ENGINEERING SERVICES SPATIALS

47359_ESP_01 - 461 Chapel Road, Bankstown

Date 23.01.2025 - Revision 1

PROJECT
461 CHAPEL ROAD, BANKSTOWN, NSW 2200
DRAWING TITLE
ENGINEERING SERVICES SPATIALS - SPATIAL MATRIX

Figure 24 Floor plan of proposed basement car park

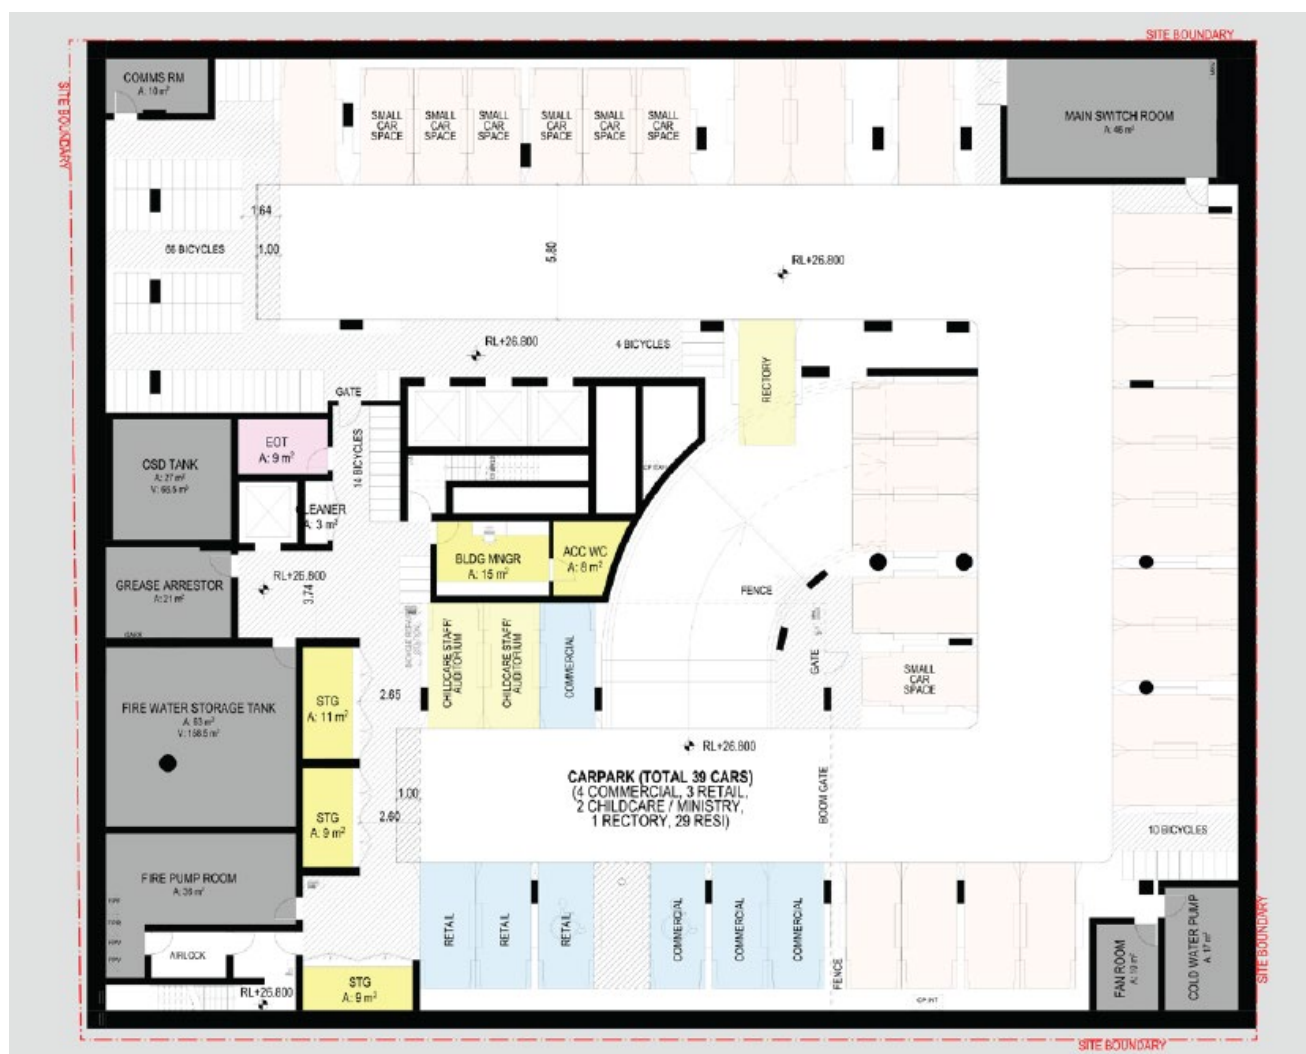
Action Reference No.	Action	Issue status
C1	Egress around fire tanks is under review. Columns to be revised as indicated. We recommend relocating the OSD tank to allow for the fire tank arrangement as shown.	Open
C2	Columns in switch room to be reviewed. If columns need to remain, the switch room may need to get deeper.	Open
C3	Egress design compliance to be confirmed. We recommend having a direct egress path to the fire control room from outside, to be confirmed by BCA.	Open
C4	We recommend allowing for traffic bollards around the substation due to the proximity to the vehicle travel path.	Open
C5	Carpark exhaust fans to be located at high level. To be coordinated with waste room layout and garbage chute locations.	Open
C6	Stair pressurisation fans to be stacked as shown.	Open
C7	Carpark intake to be coordinated with landscaping in communal outdoor space.	Open
C8	Plant to be reviewed by acoustics to determine acoustic treatment required for space. Intent for plant space to be open to above to allow for ventilation to plant.	Open
